## **Cottam Solar Project: Applicant's Responses to ExA Second Written Questions, January 2024**

### **Question 2.13.11: Electromagnetic Fields.**

Figure	Cable Route Crossings		
Job	Cottam		
Client	Island Green Power		
Figure No.	1	Revision	A
		Date	04/11/2022
Drawn	BB	Checked	JR
		Scale	1:70,000 @ A3
Job No.	21-1088.01		Central GR
			485466E 387794N

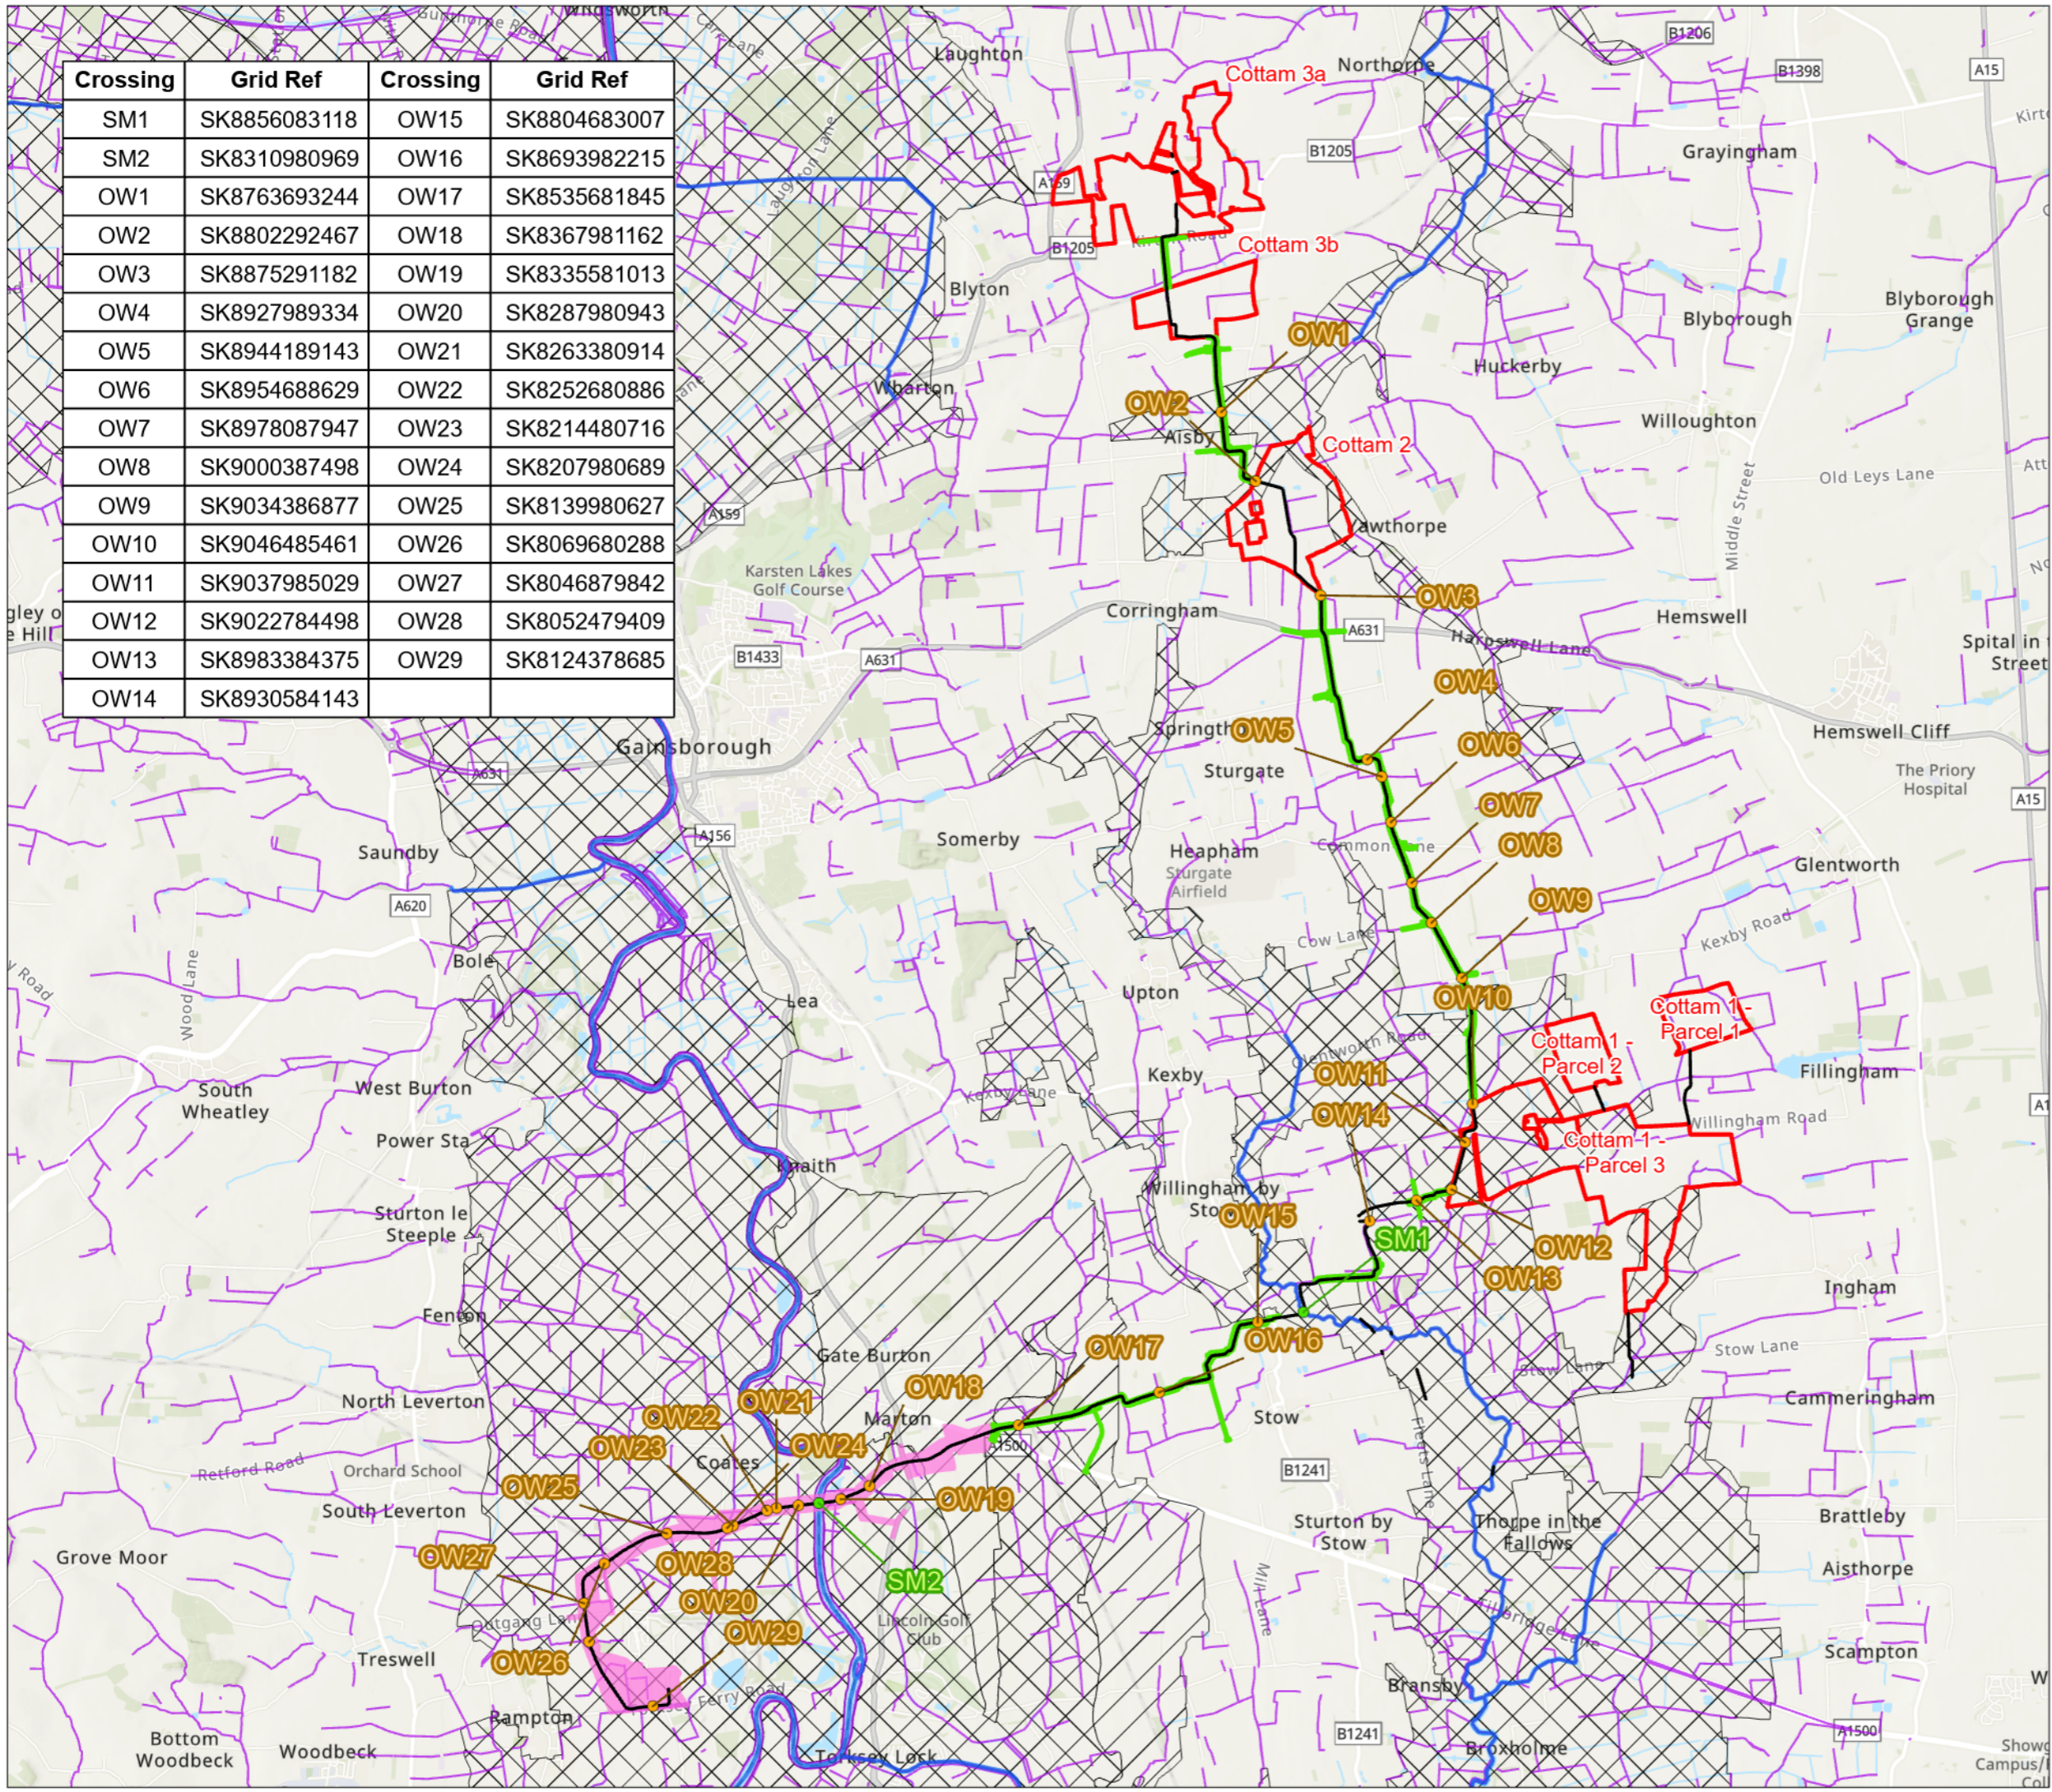
The River Till and the other 30 or so number water course crossings need to be considered in any conclusions.
